From: Simon Davis
Sent: 01 October 2021 15:55
To: 'Julian Evans' [REDACTED]
Subject: RE: P/111/21/RES - Sefter Road - Planning progress

Subject: RE: P/111/21/RES - Sefter Road - Planning progress

However, having looked again at the application/my previous notes, it is my intention to refuse the application on the basis of overdevelopment and harm to character.

Project
Land adjacent to Seftor School House
Seftor Road
Bignor Regis
PO21 3EE
Drawing Title
Plots 2 and 3
Floor Plans and Section

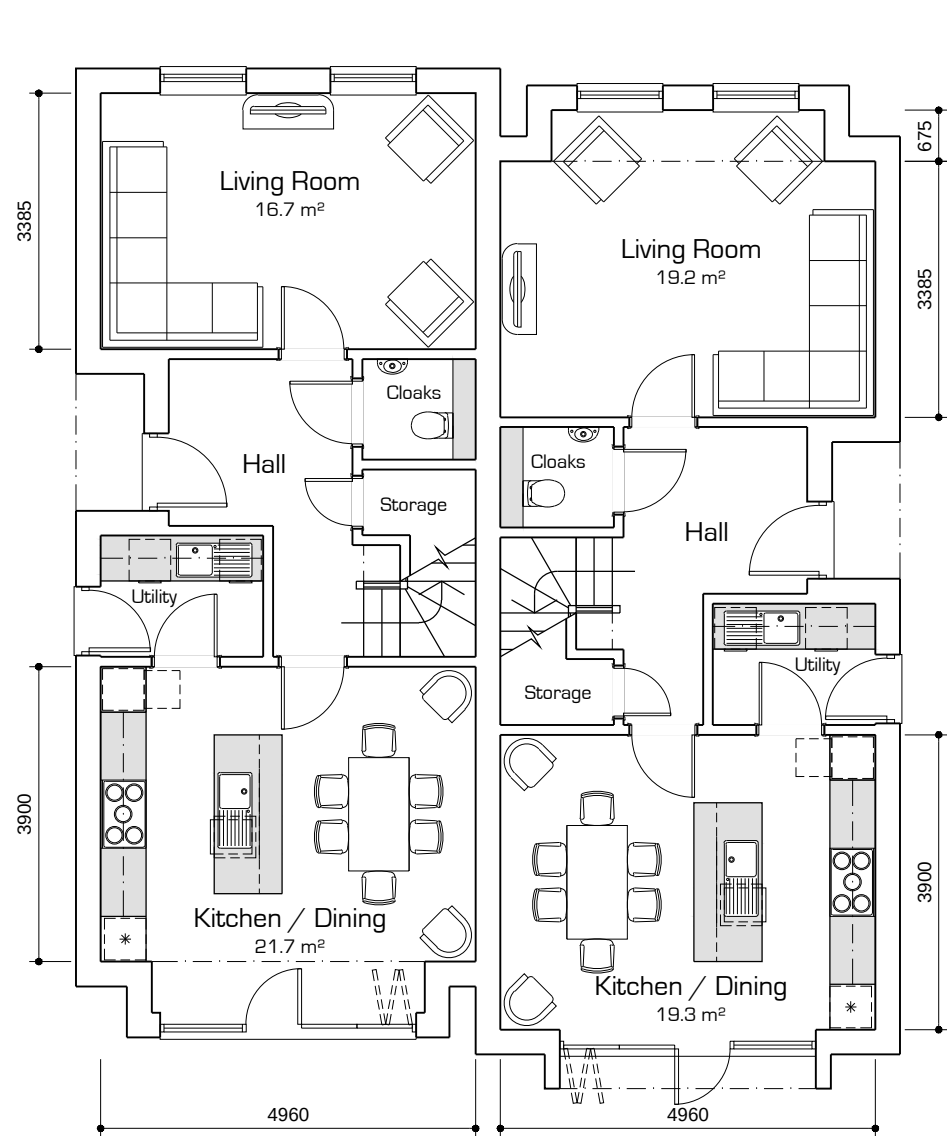
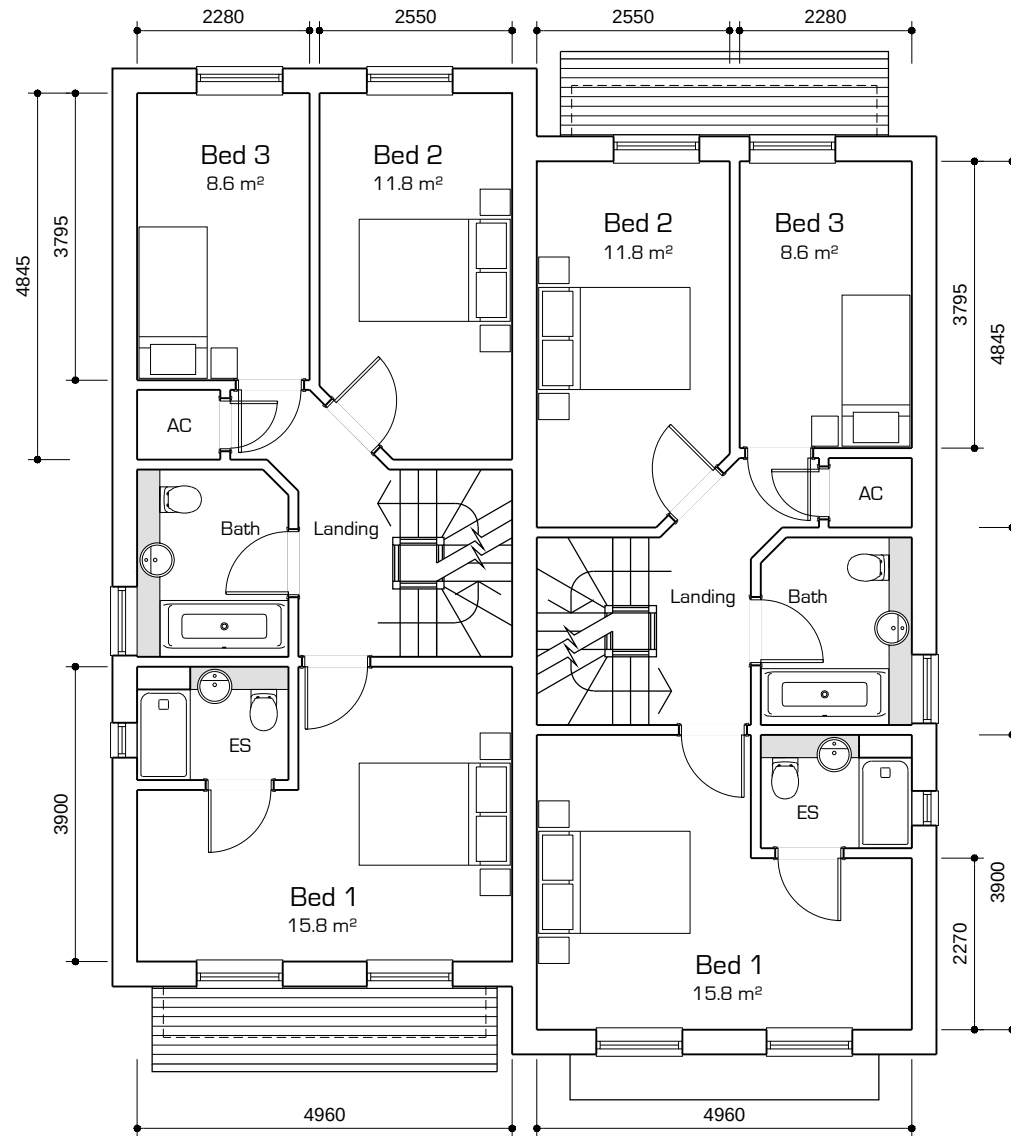
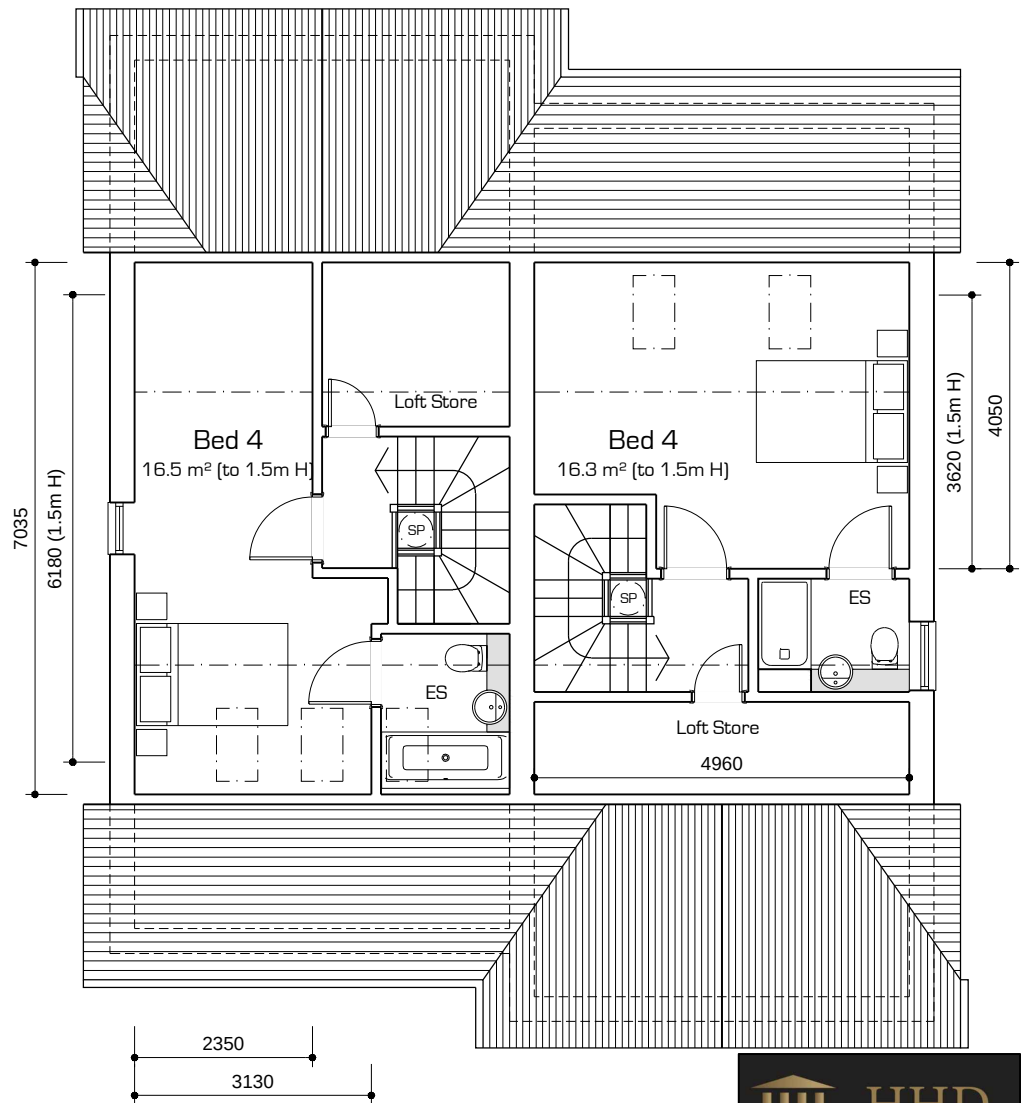
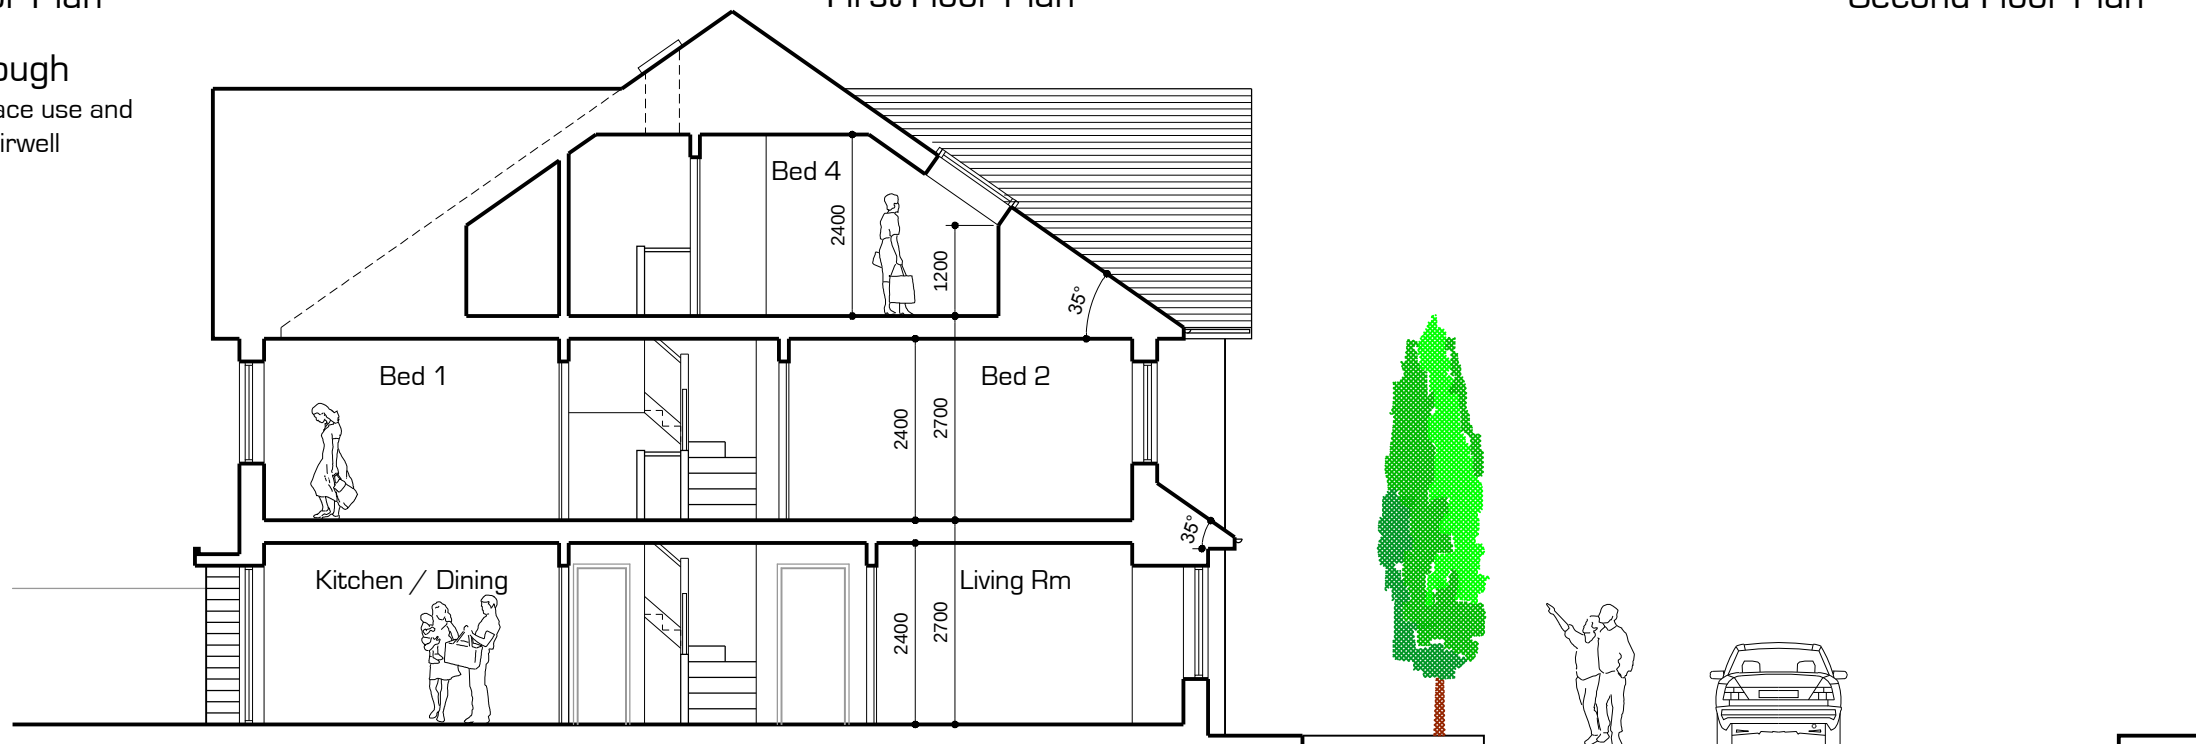
I acknowledge that we have given outline consent for 4 semi-detached 3-bedroom houses and 2 detached 4-bedroom houses and so we have to allow this number of houses and mix/no of beds. However, I have concerns with the closeness of the houses to each other, their size (floor areas are well in excess of minimum space standards), the height (inc roof level accommodation) and materials (weatherboarding not considered appropriate to the local context). Also not all gardens (plots 1 & 2) meet the 10.5m depth requirement as per the Arun Design Guide and garden depths across the layout appear to extend beyond/into the fenced easement to the stream.

I acknowledge the proposed residential development on the strategic allocation next door however the submitted RM for that site (P/79/21/RES) has a large SUDS area and POS adjacent to the boundary with houses at least 100m away thus minimising the impact on this urban extension on the rural character of the area. I therefore do not consider that this sets any form of precedent for an urban form of development on the plot. In addition, house types on the RM (WE, AR, GO, SR) that are closest to your site are all proposed as straight two storeys (no roof accommodation).
